ENG-PPR21008-R1-FDR-redlines.pdf Markup Summary

ad development of Super Star Car Wash
of the "Final Drainage Report for Falcon
2019. Please provide the PCD filing number
that this FDR was filed under:
SF-19-001

PPR-21-008

## DRAINAGE BASIN MAP

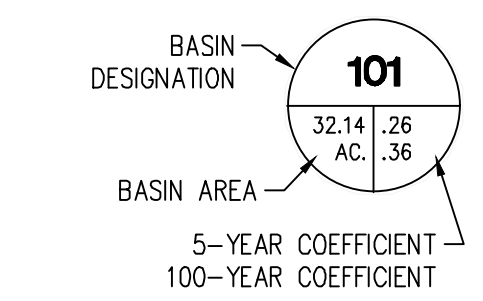
label ROW

label existing storm drains

please add a few more flow arrows, maybe delete the traffic arrows
